Planning Act 2008 (as amended) and The Infrastructure Planning (Examination Procedure) Rules 2010 (as amended) - Rules 8(3) and Rule 17

Application by Keuper Gas Storage Limited for an Order Granting Development Consent for the Keuper Gas Storage Project

Changes to the original application

FOR CONTINUATION SEE DWG. No 13-03-01/HOL/24/342

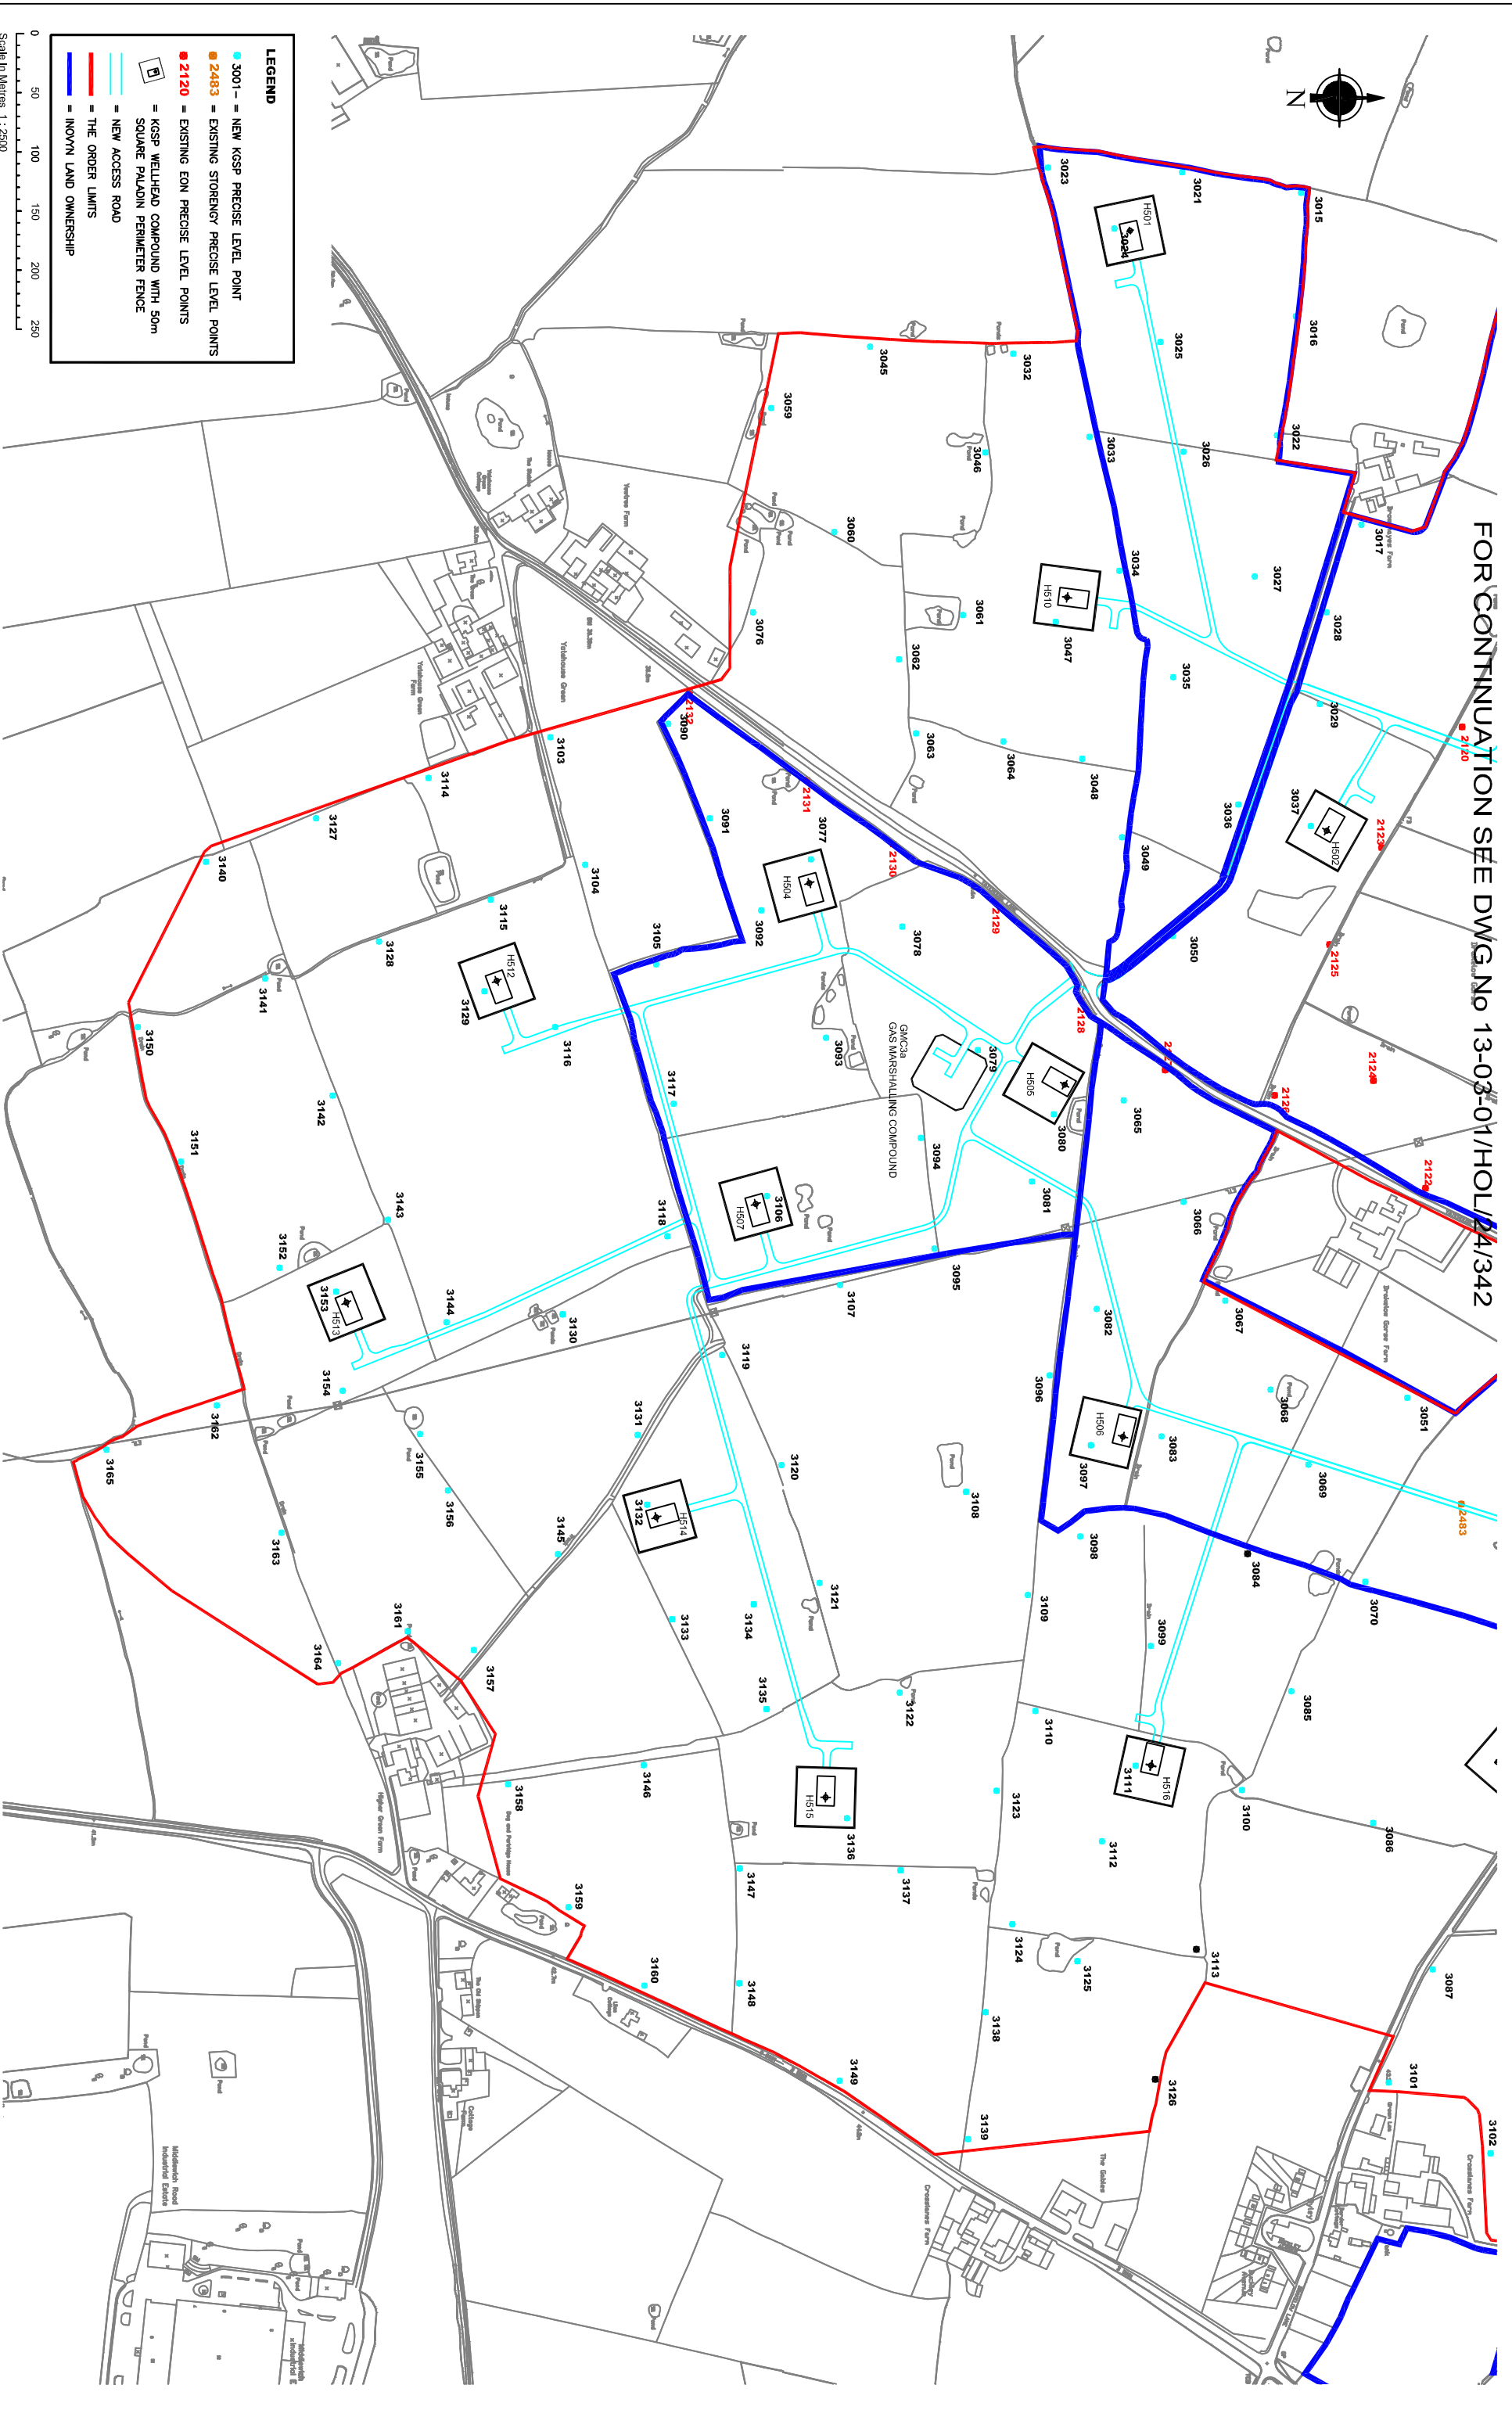
The two precise level points in question would be moved as follows;

- Point 3046 (as shown on application drawing 13-03-01/HOL/24/343) [APP-119] would move north east by approximately 25m; and
- Point 3076 (on the same drawing) would move west by approximately 15m.
